OBJECTION TO PLANNING APPLICATION FOR ERECTION OF GARAGE WITH
RAISED PATIO (RETROSPECTIVE) AT 167 BRADLEY ROAD, BRADLEY,
HUDDERSFIELD, HD2 1QF

LPA: 2024/93151

Proposed Floor Plans

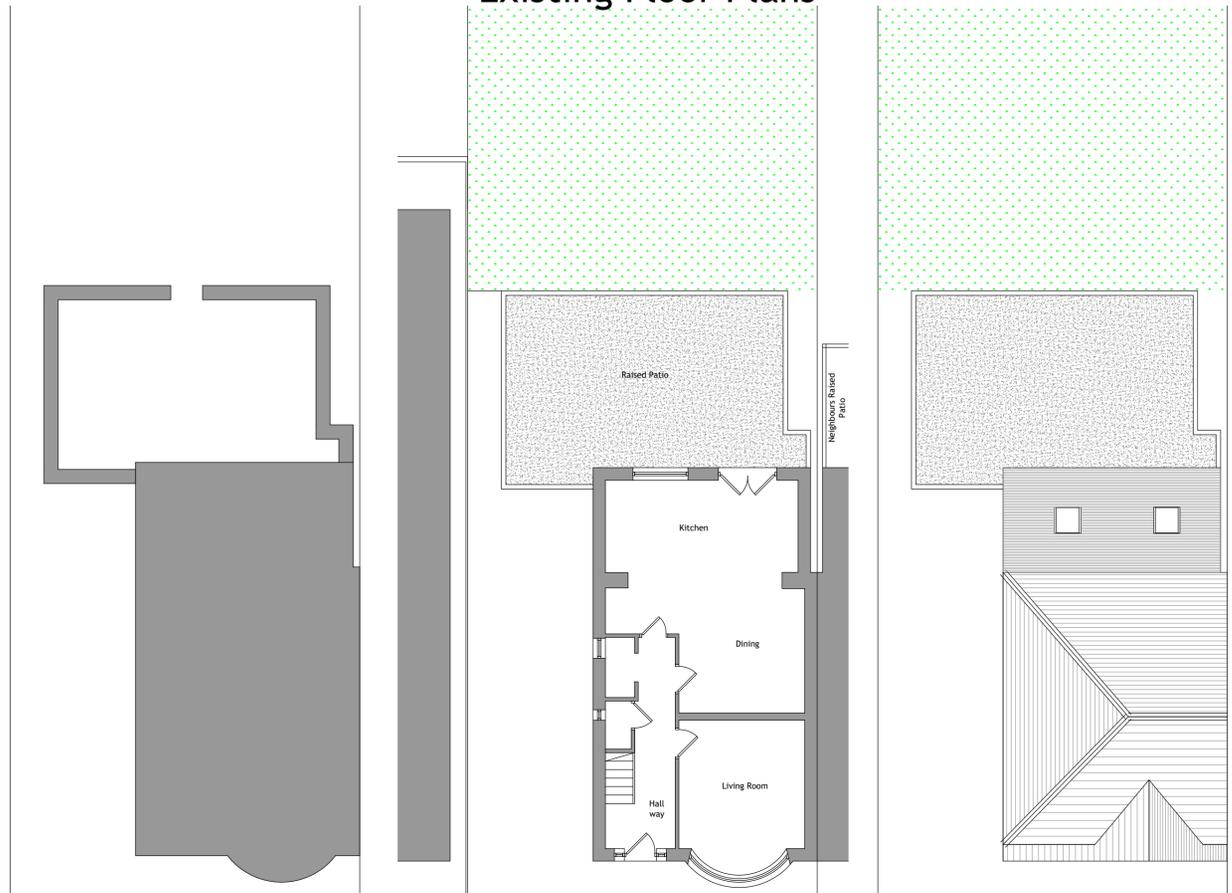
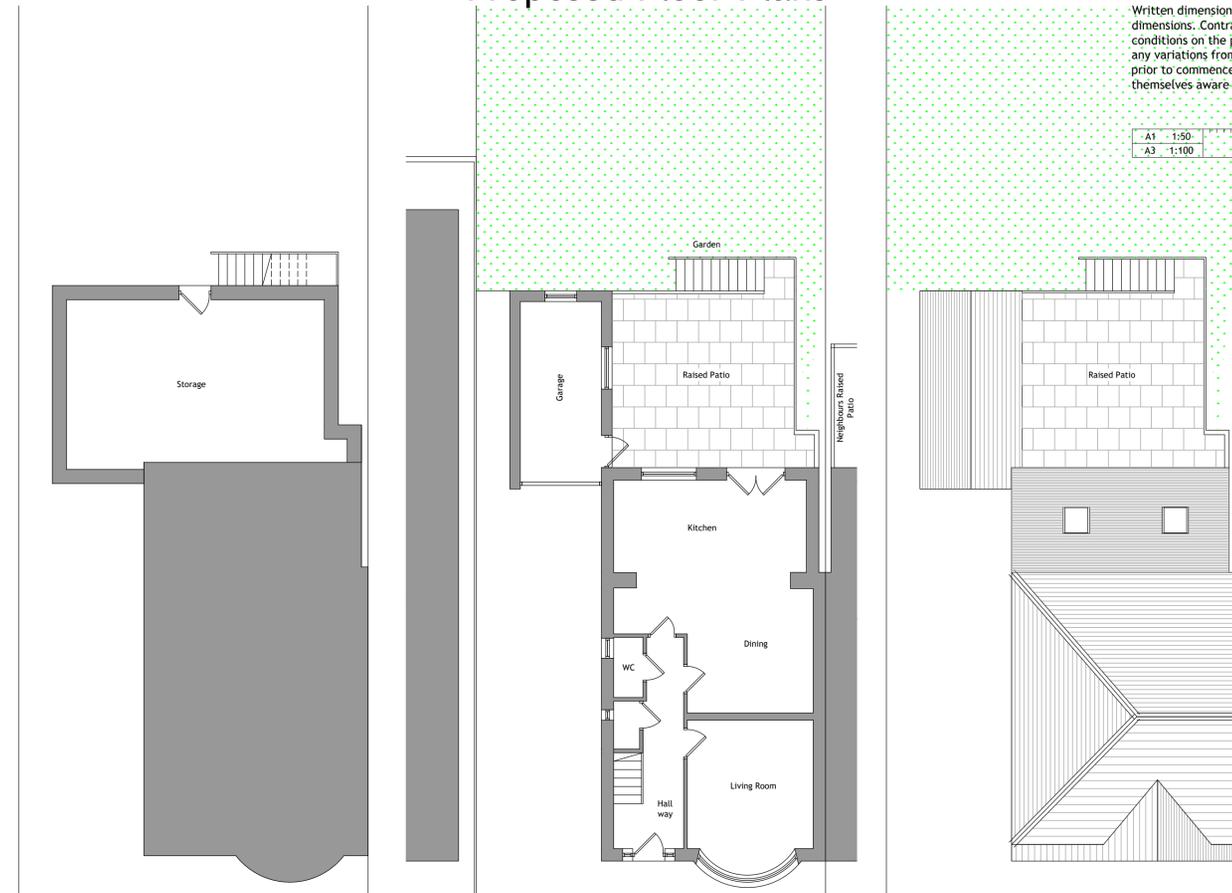
I have viewed the floor plans and elevations, in my opinion they are misleading. The lower ground floor extension which does not share the building materials of the house, also requires planning permission and has been conveniently omitted. The appearance and layout are totally out of character doesn't comply with Planning guidance and other planning policies as I see.

East Elevation (Side) 1.100 South Elevation (Rear) 1.100

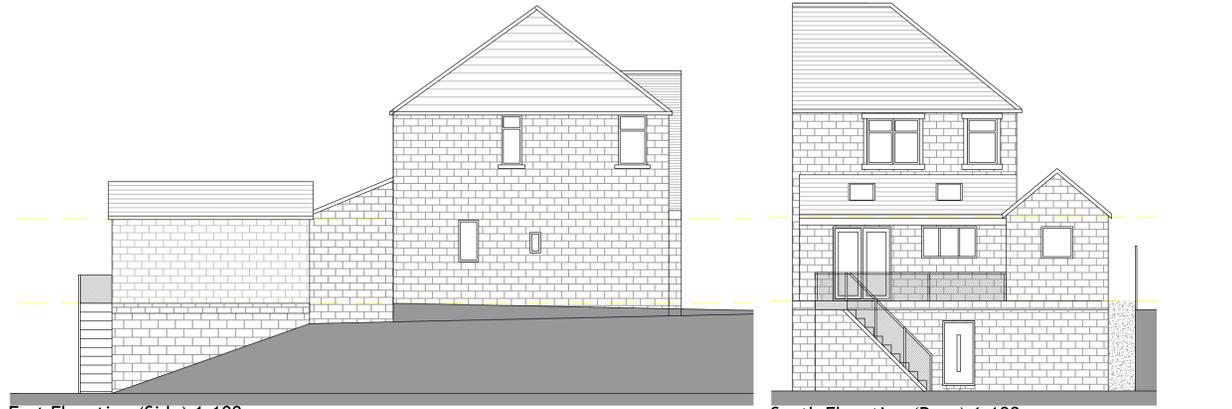
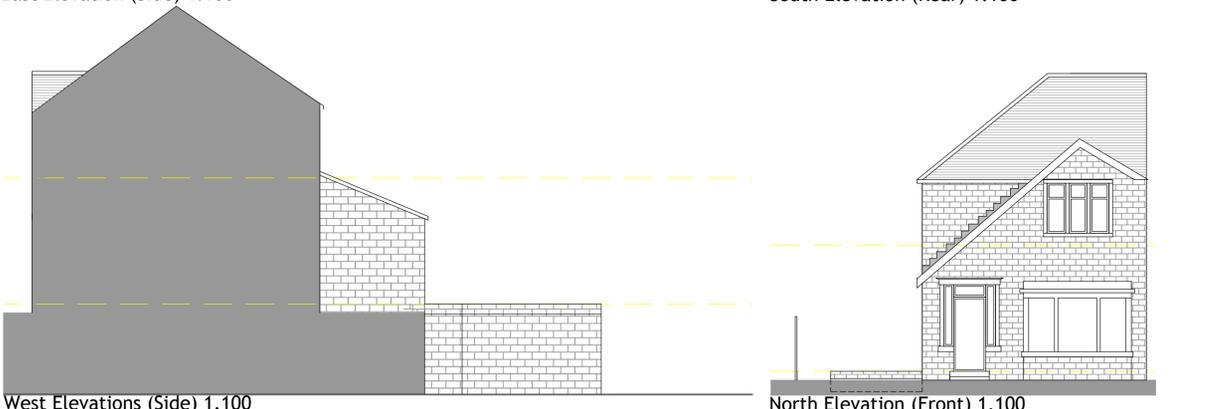
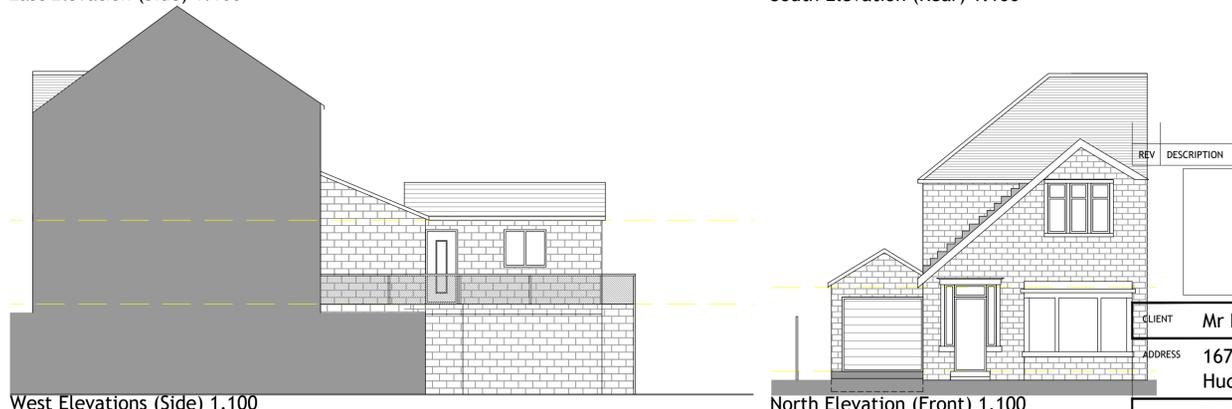
The terrace which projects out approx. 8m from the original house is raised some height above my patio area taking away my privacy. No consultation or boundary wall agreement has been in place and little or no consideration has been given to me or other residents during a protracted build.
